Memorandum

Project: Koneru Residence Stair – Permit Application Number 2112-250
Mercer Island, WA
Structural Permit Review Comment Responses

OPEN RISER STAIR - LOWER SECTION  
SCALE: 3/4" = 1'-0"

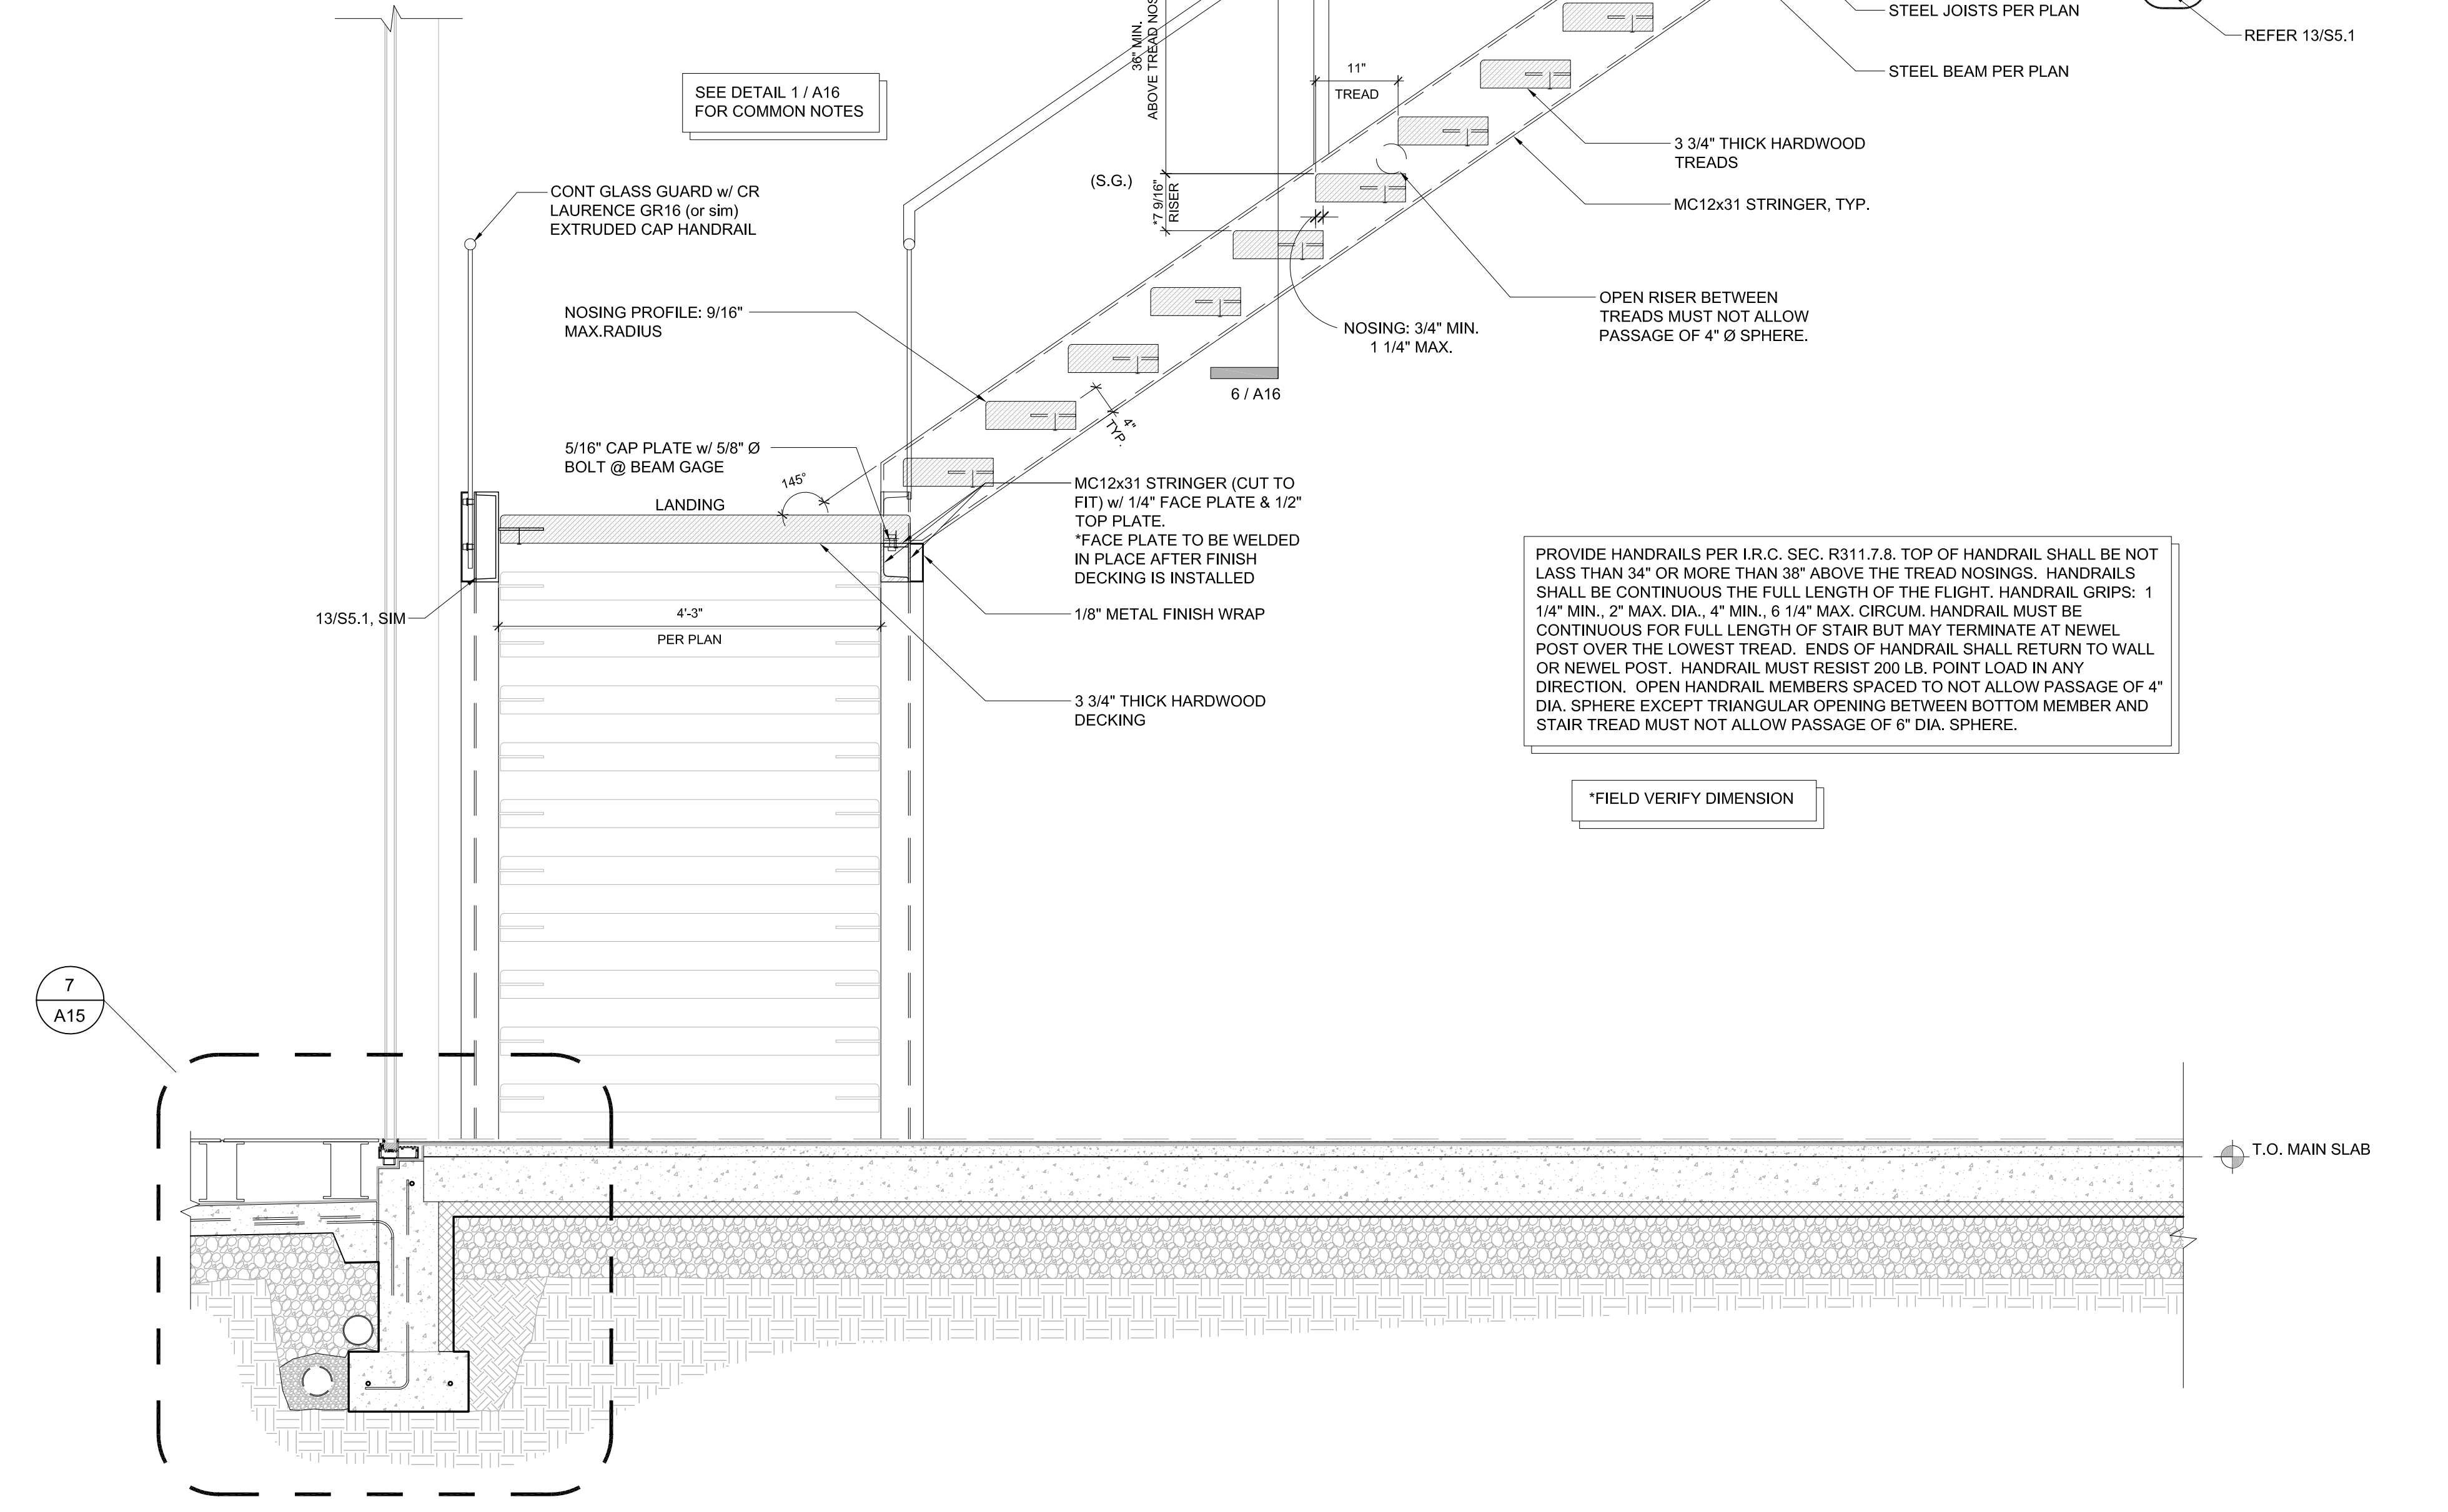
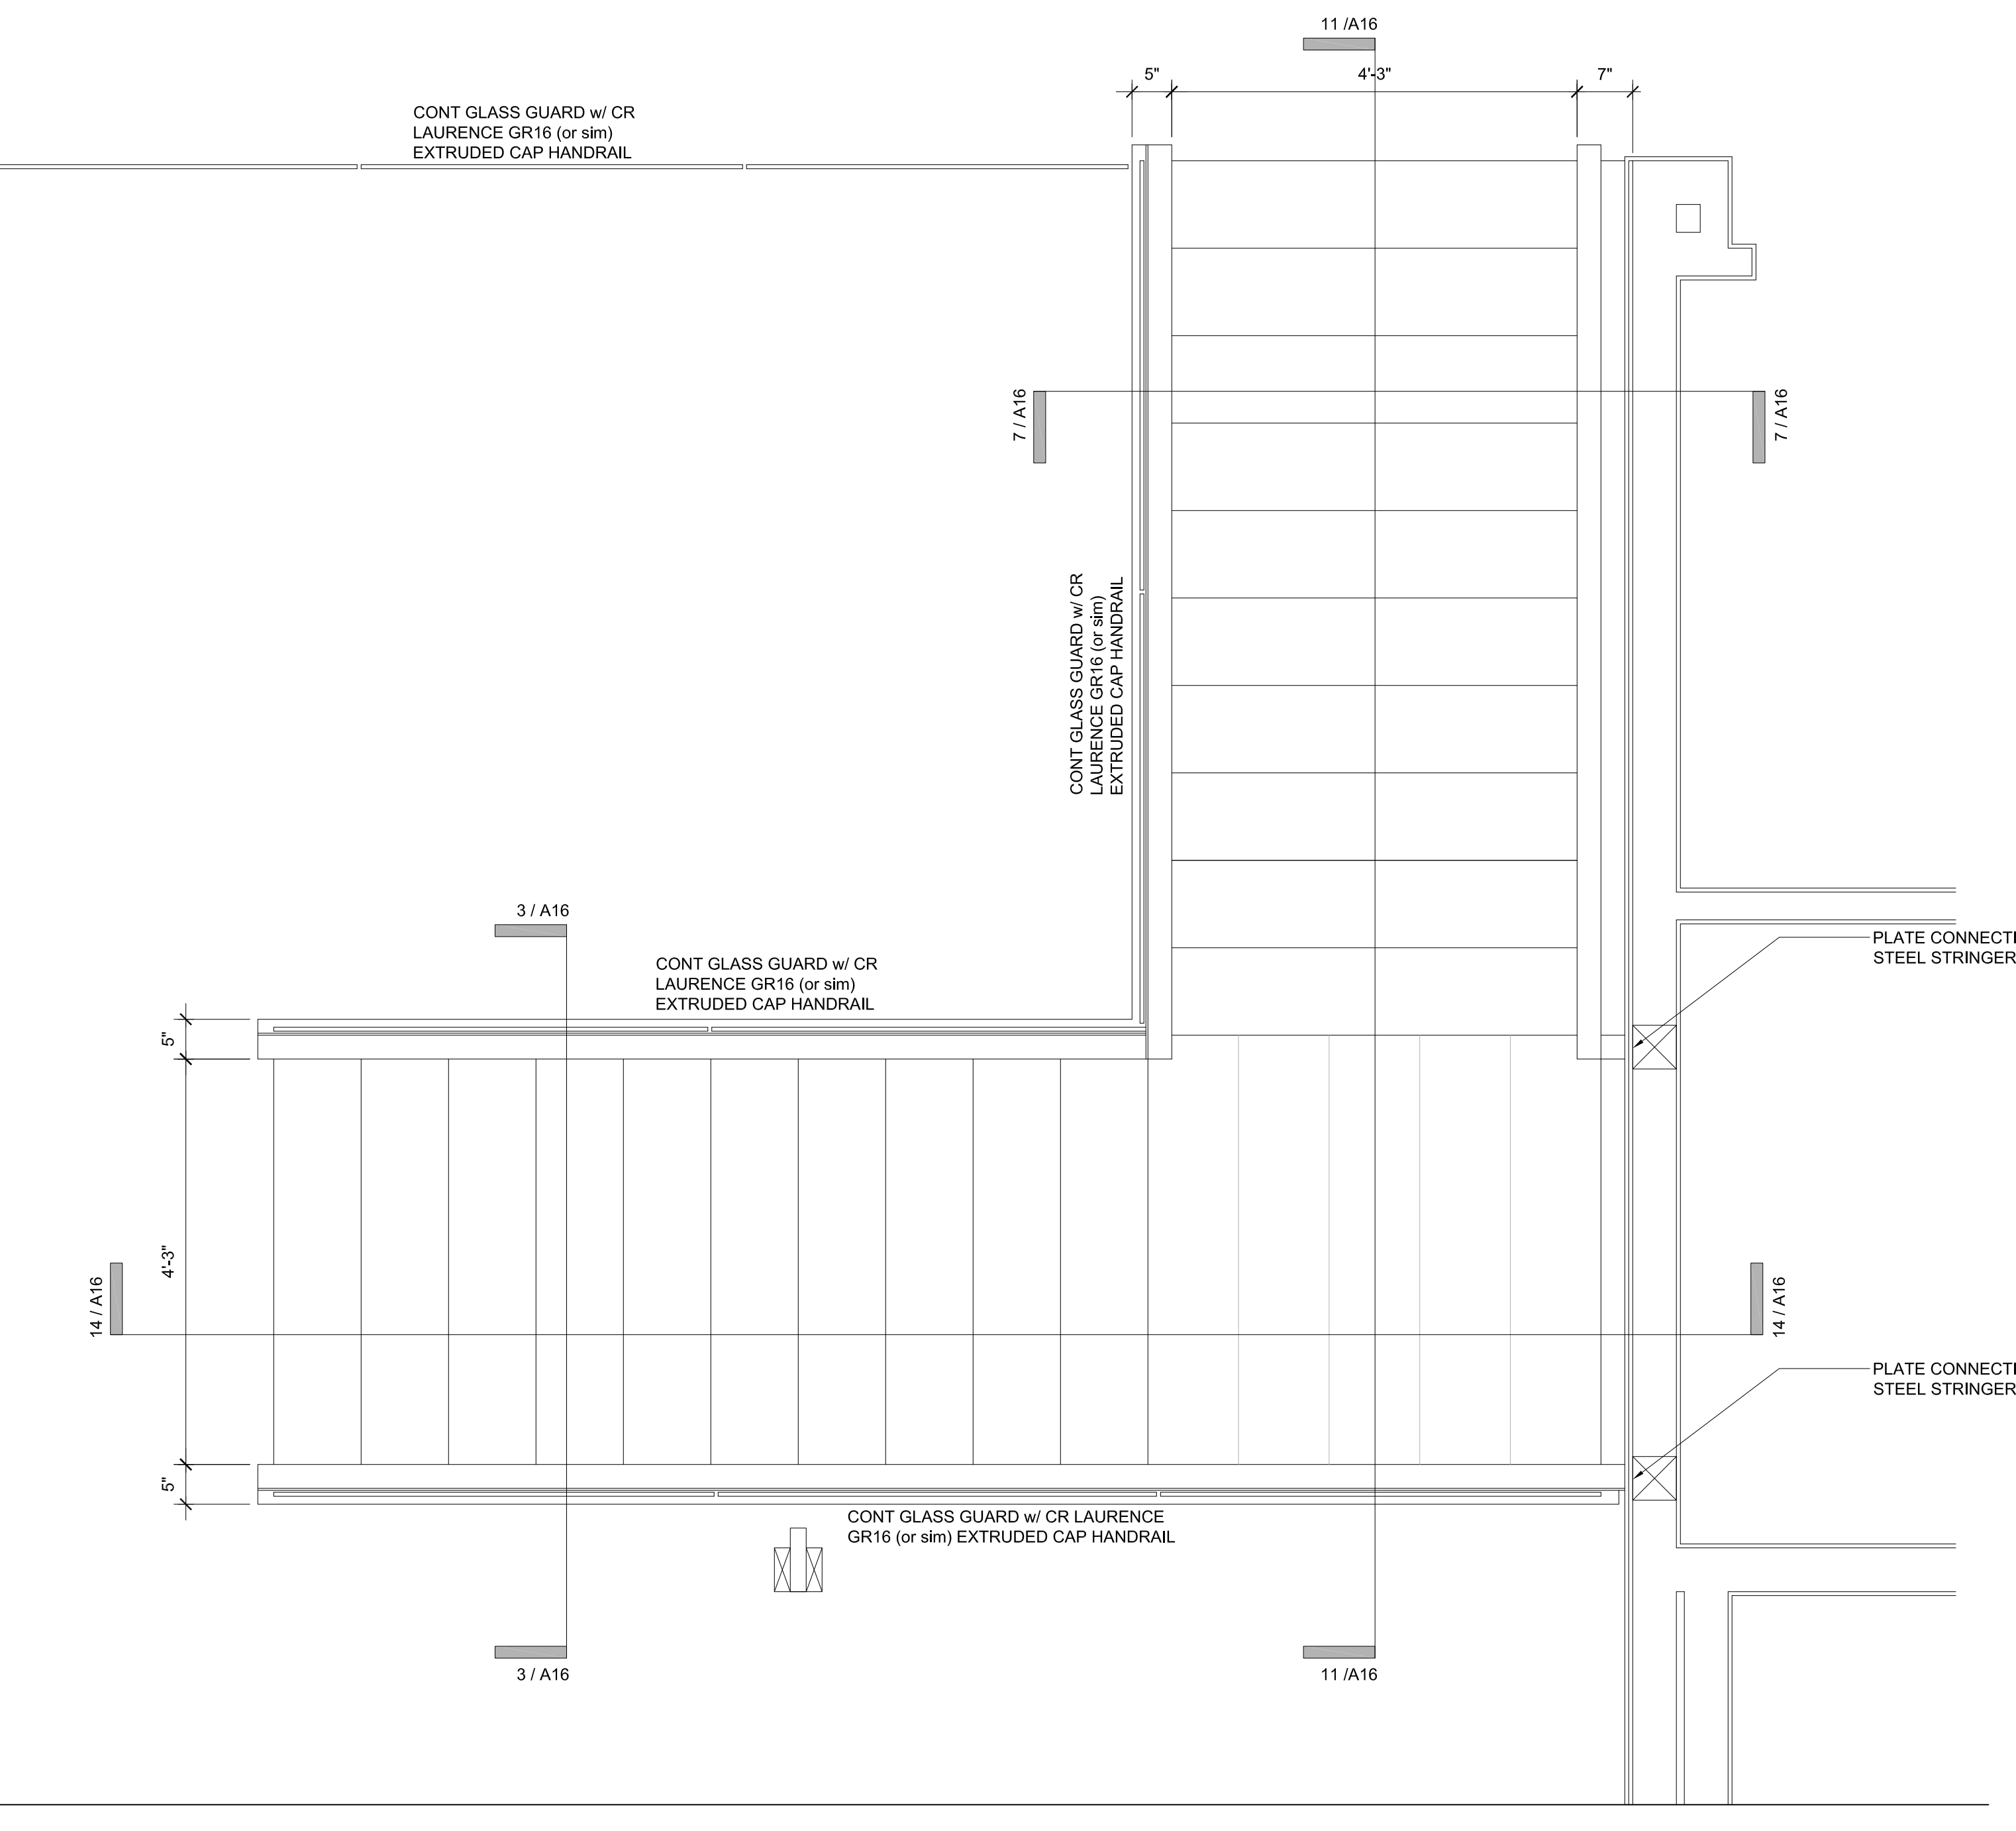
2. Clarify shop vs. field welding (note if unit will be shop welded and delivered in one piece).

SSF Response: It is assumed that portions of the stair will need to be field welded. Stringer splice points and details have been provided on plan.
